From: Sue Howell <Sue.Howell@arun.gov.uk>
Sent: 06 December 2021 16:39
To: Planning.Responses <Planning.Responses@arun.gov.uk>
Cc: Michael Eastham <Michael.Eastham@arun.gov.uk>
Subject: Planning Consultation on: A/184/21/PL

Response to Planning Application

Application ref: A/184/21/PL

Description: Construction of a weir upstream of the culverted road access to the Land South of Water Lane Development, Angmering as Phase 1 of the Angmering Flood Alleviation Scheme. This application is in CIL Zone 1 & is not CIL Liable as other development.

DRAWING No: ANG-WSP-XX-ZZ-DR-D-0003	REV: P01
-------------------------------------	----------

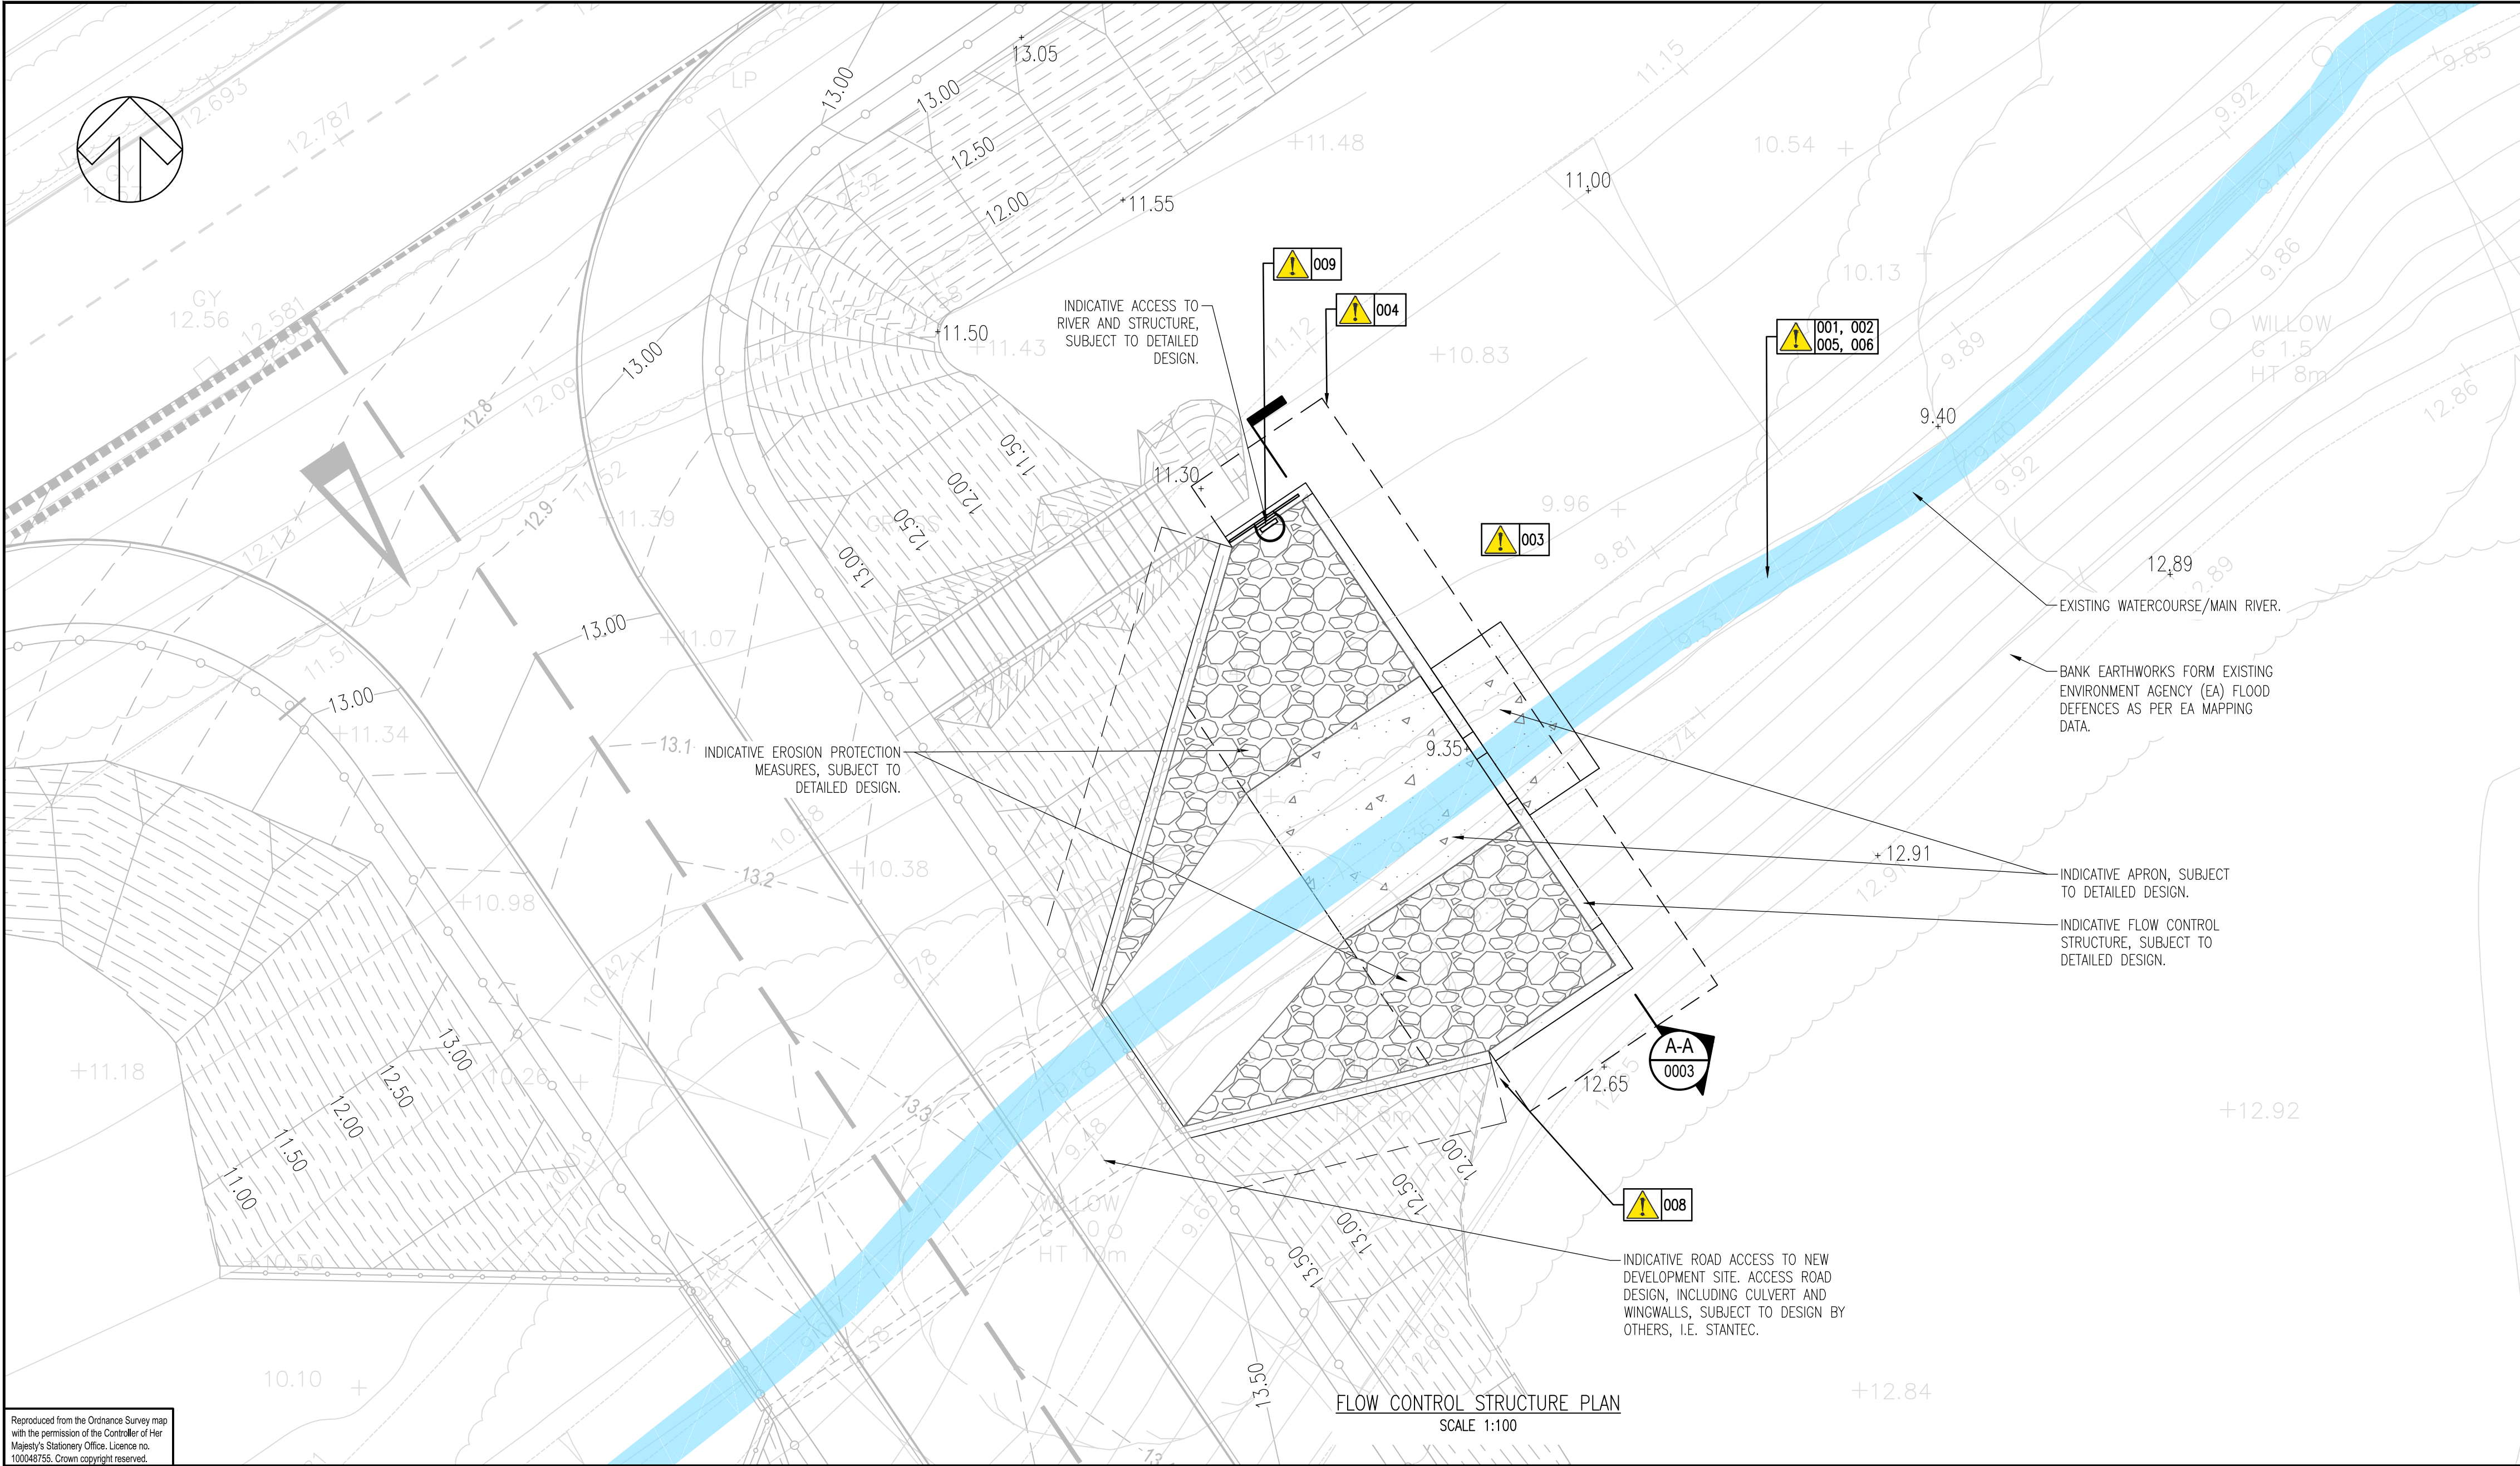
The details submitted with this application including Indicative Flow Control Structure Plan and Section ANG-WSP-XX-ZZ-DR-003 Rev P01 and the Landscape and Ecological Management and Maintenance Plan for the construction of a weir to cater for extreme storm events. Potential water holding in this location for dissipation within a 13-24hr period under these conditions should not pose any significant conflict with the landscape proposals previously submitted and approved for this location.

The tree species specified would generally appear suitable to be tolerant of short periods of wet ground and have been detailed to be planted away from the perceived permanent wet areas in this location.

The potential impact of the proposals would appear to pose minimal detriment to the landscape proposals previously submitted and approved in this location.

No further mitigation required to the approved landscape scheme, retaining the tree planting away from the lowest part of the ditch formation and therefore providing the greatest potential for the tree establishment in this location.
